WEST SUSSEX COUNTY COUNCIL CONSULTATION

TO:	Arun District Council FAO: Aishwarya Reddy
FROM:	Highways, WSCC
DATE:	23/12/2024
LOCATION:	2 Rose Cottages, Climping Street, Climping, BN17 5RH
SUBJECT:	CM/45/24/HH Part single, part two storey side and single storey rear extensions and creation of a drive, following demolition of existing extensions.
DATE OF SITE VISIT:	N/A
RECOMMENDATION:	Advice
S106 CONTRIBUTION TOTAL:	N/A

DRAWING TITLE  
Proposed Floor Plans and Site Plan

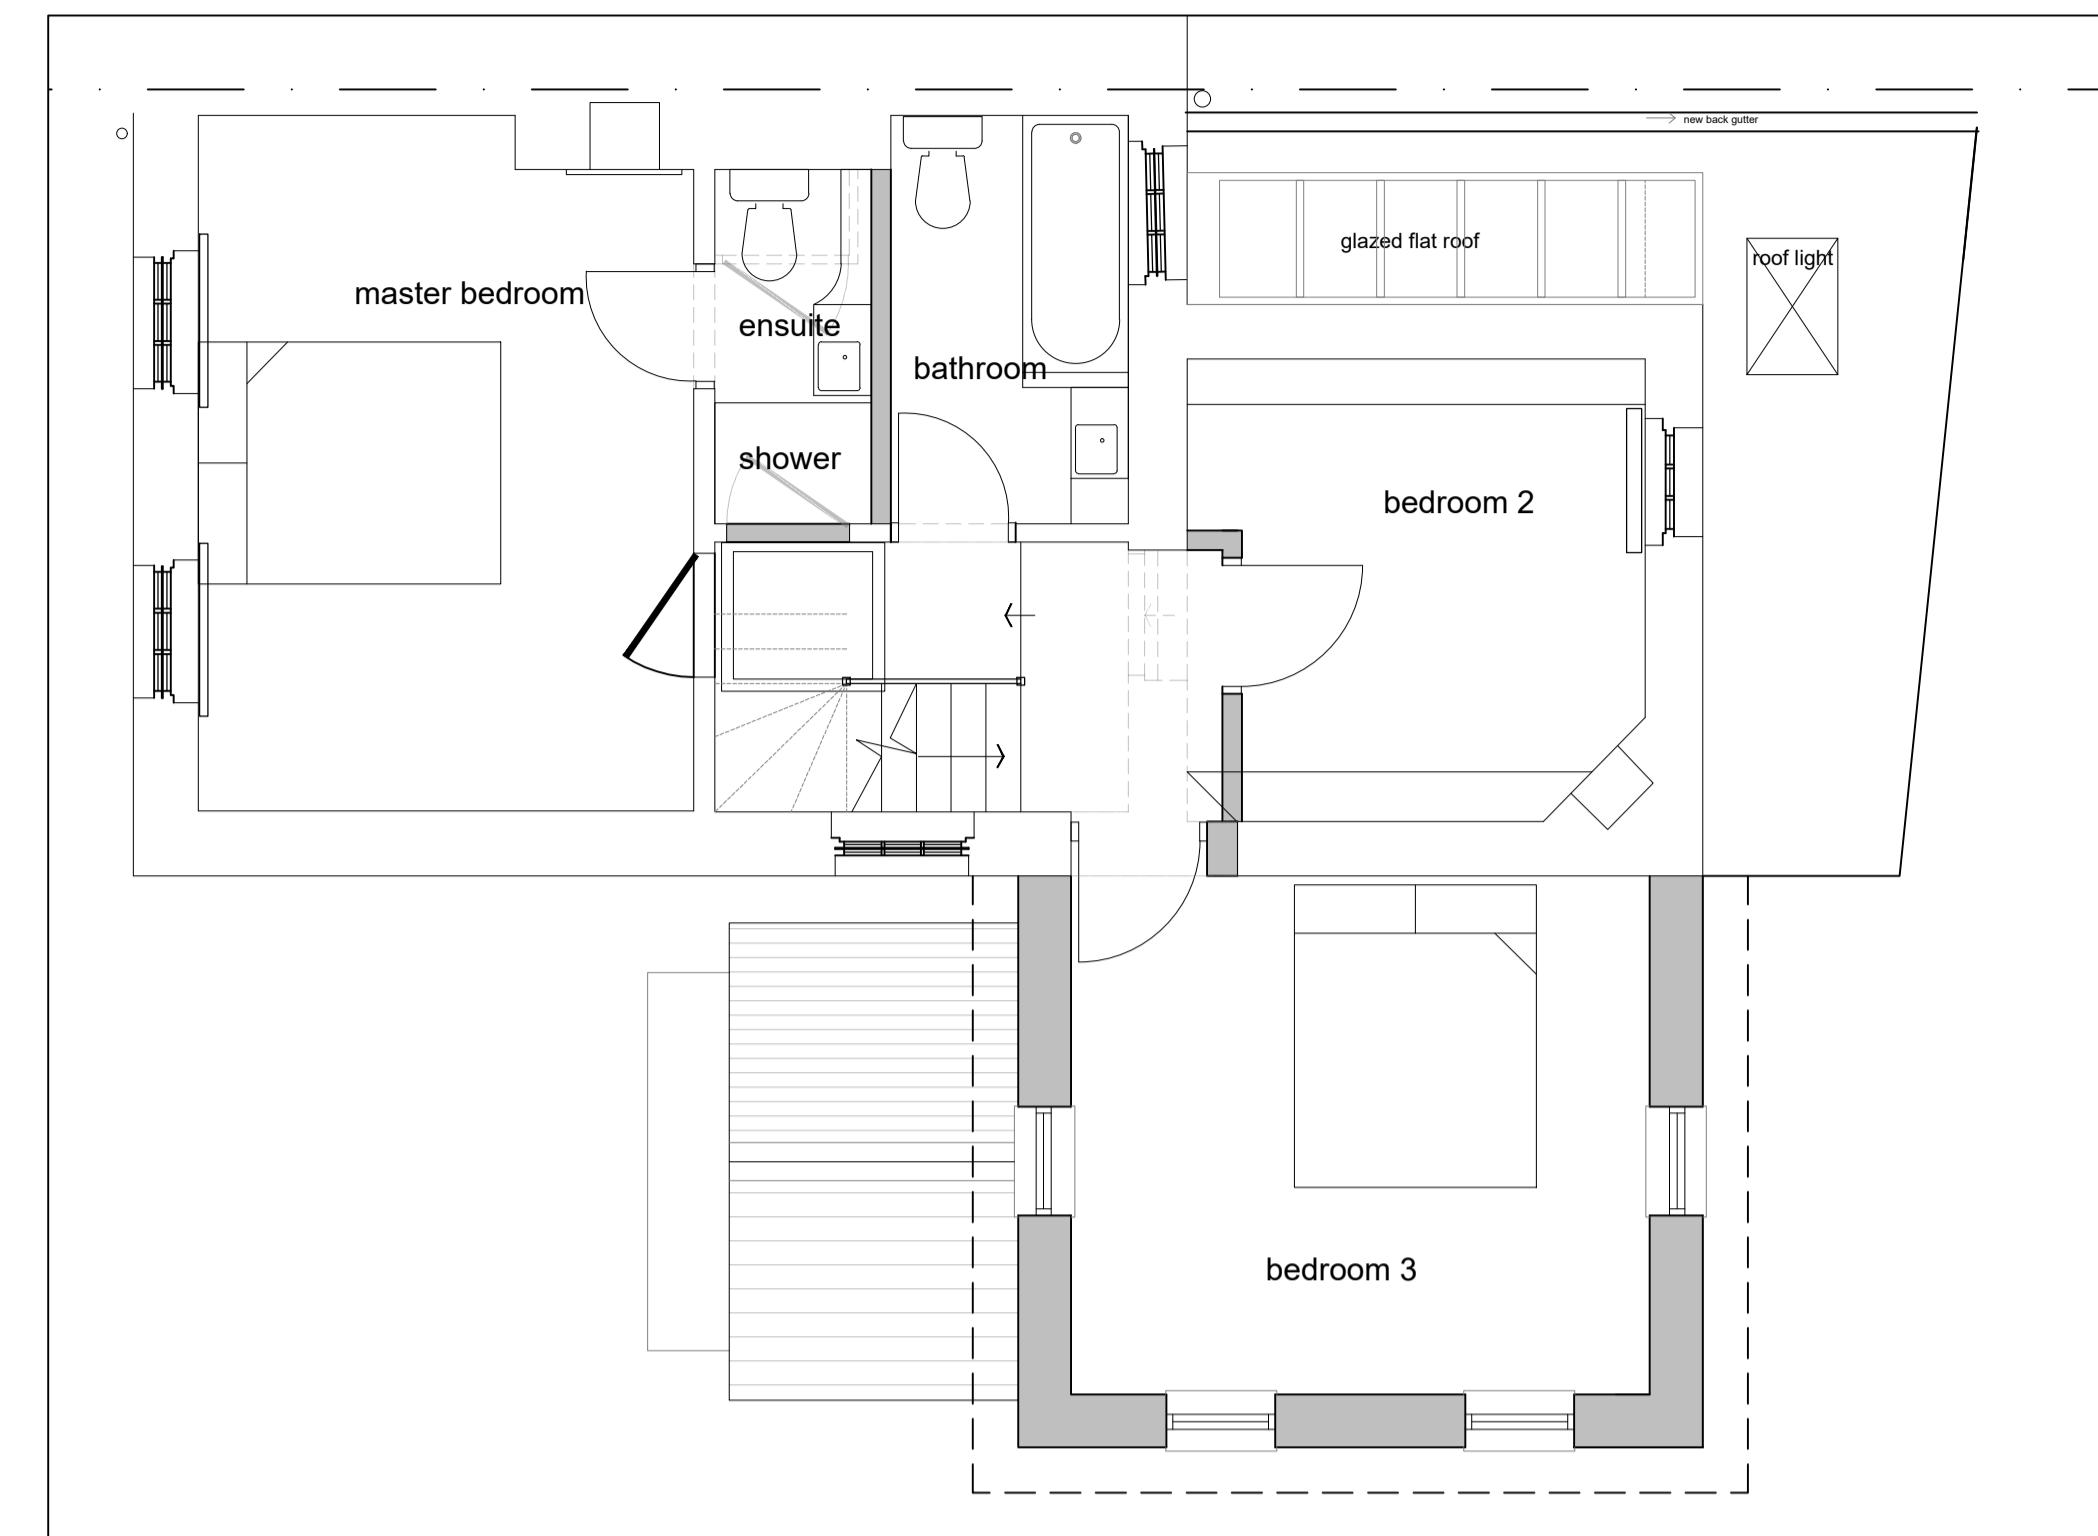
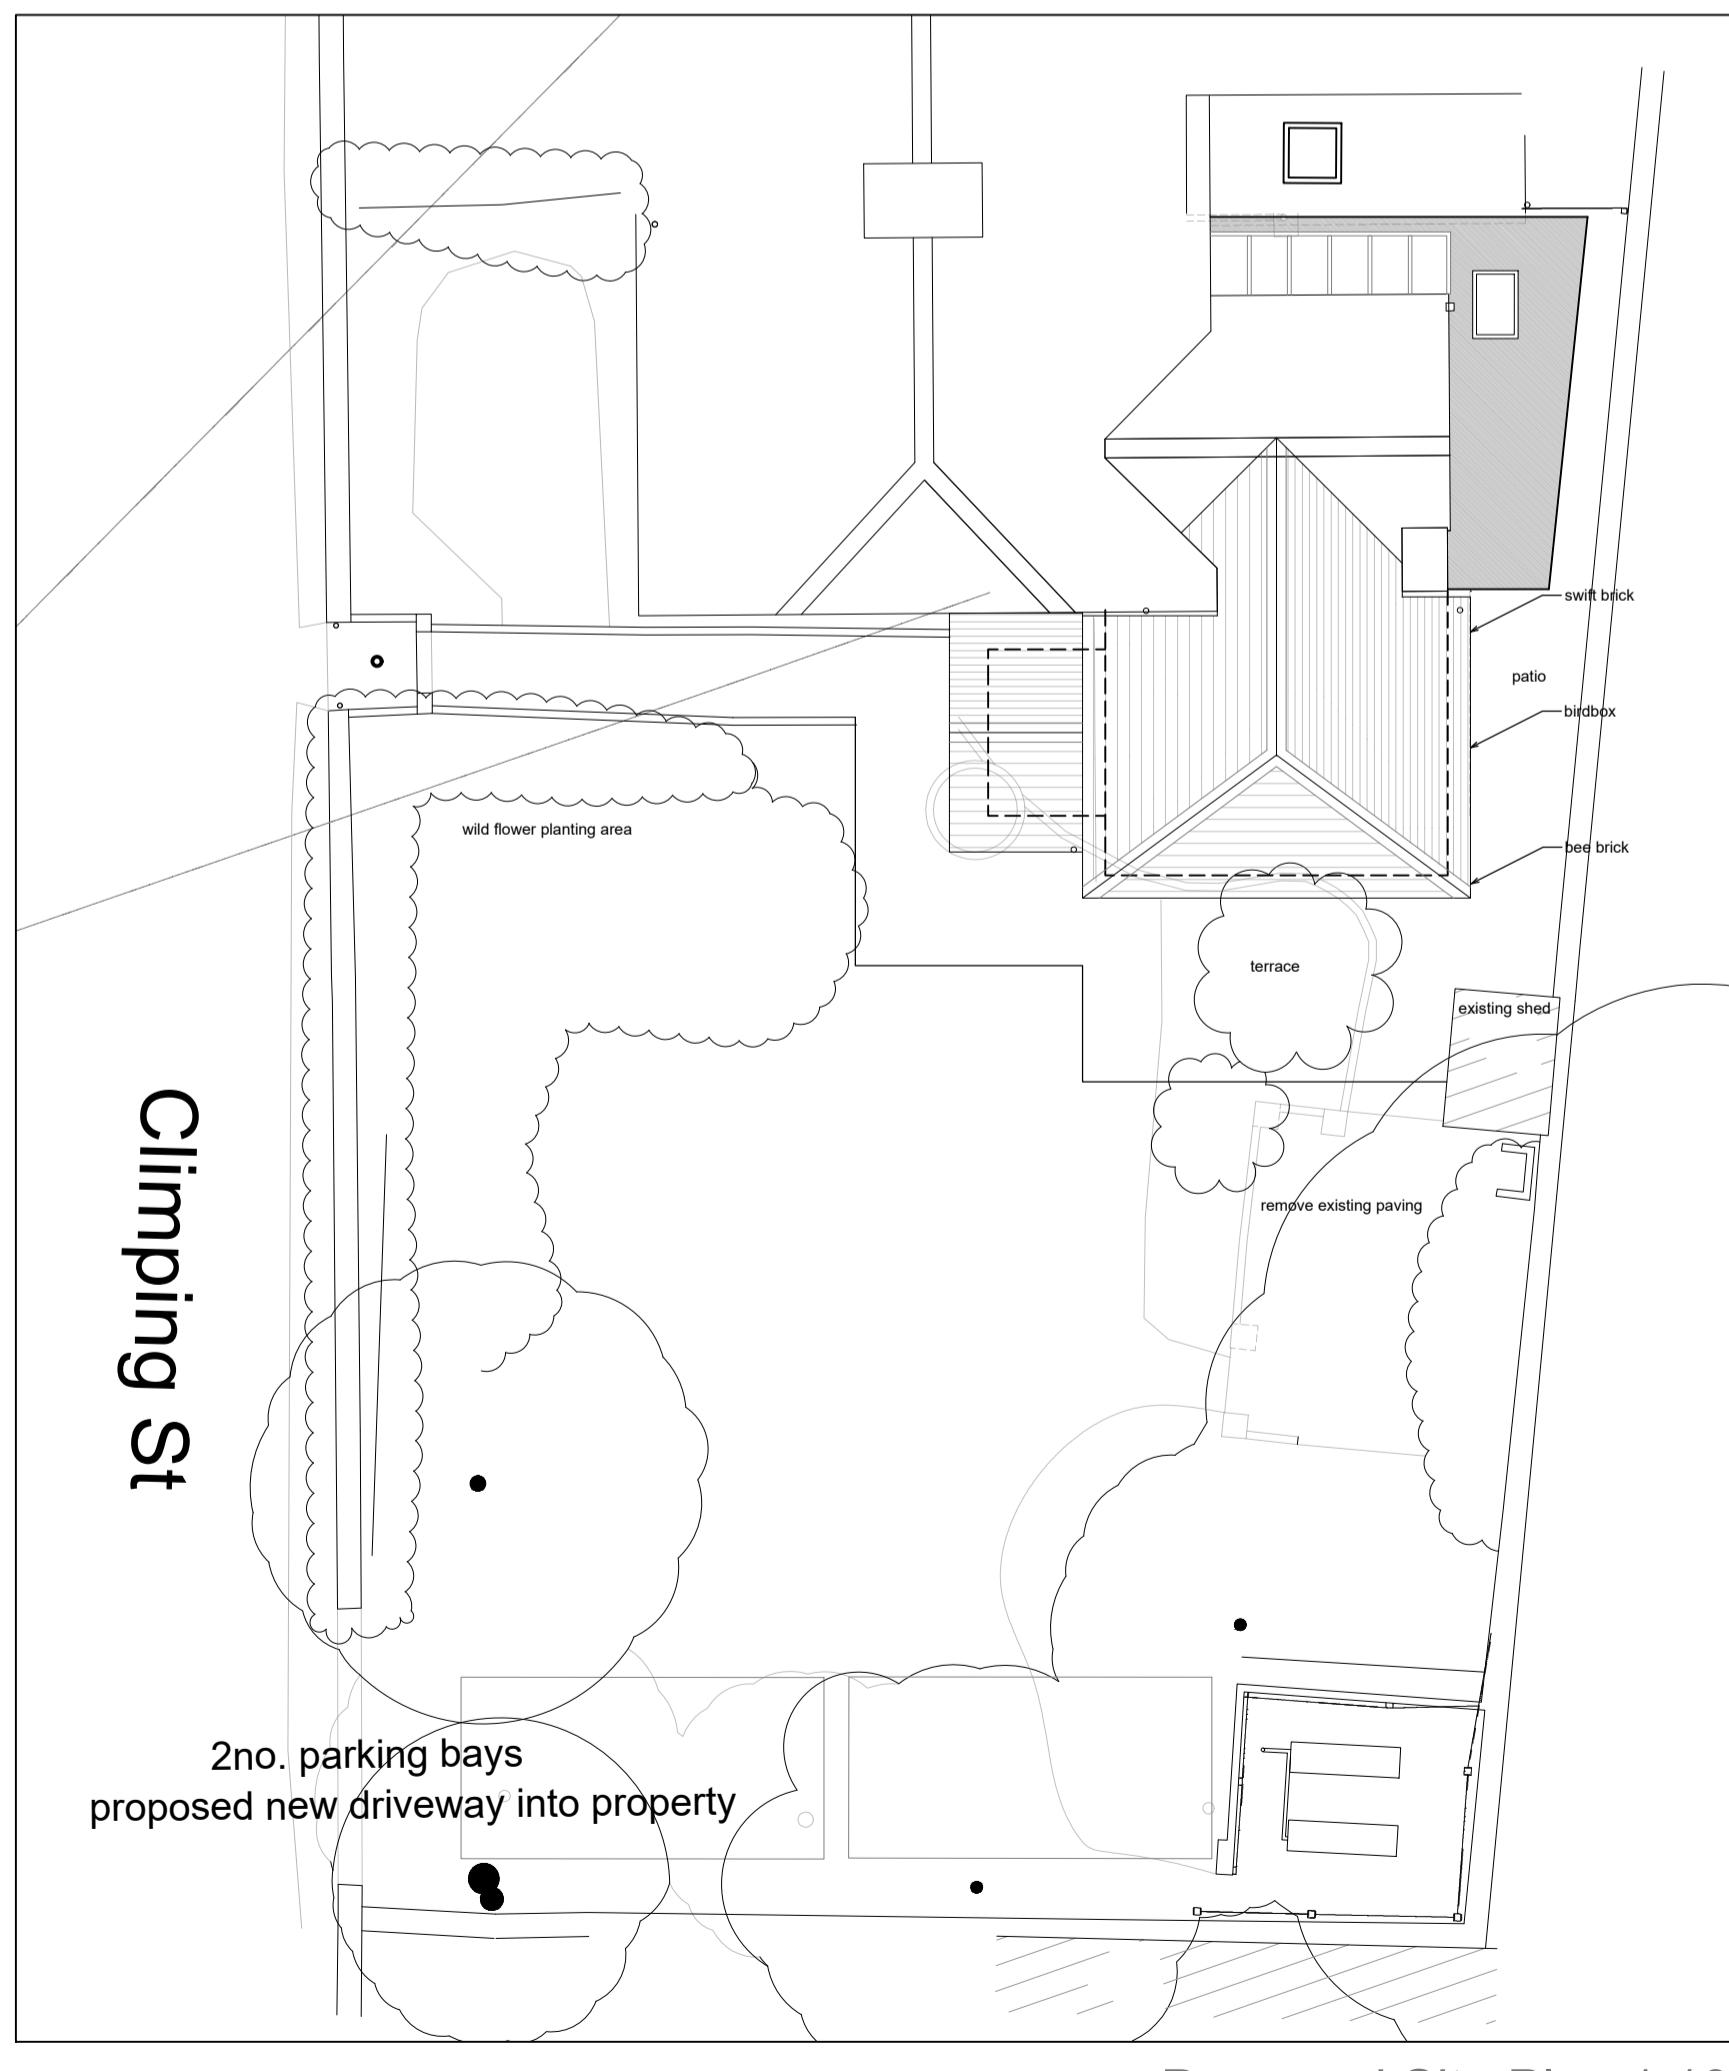
A new vehicular access point is proposed on Climping Street, to facilitate access to a new drive providing two off-street car parking spaces. The proposed access works will be subject to a vehicle crossover (VCO) licence obtained through the local WSCC Highway Area Office and constructed to a specification agreed with the local WSCC Highway Area Engineer.

Visibility splays of 2m x 25m have been demonstrated in accordance with Manual for Streets (MfS) parameters for a 20 mph speed restriction. The LHA request that visibility be secured by condition, to ensure suitable visibility is maintained in perpetuity.

The proposed drive appears of suitable size to accommodate two off-street car parking spaces. On-site turning does not appear achievable, so vehicles may have to exit in a reverse gear – however, this would not be anticipated to give rise to an adverse highway safety impact, owing to sufficient demonstrated vehicular visibility and that Climping Street benefits from good forward visibility in this location.

No part of the development shall be first occupied until visibility splays of 2 metres by 25 metres have been provided at the proposed site vehicular access onto Climping Street in accordance with the approved planning drawings. Once provided the splays shall thereafter

be maintained and kept free of all obstructions over a height of 0.6 metre above adjoining carriageway level or as otherwise agreed.
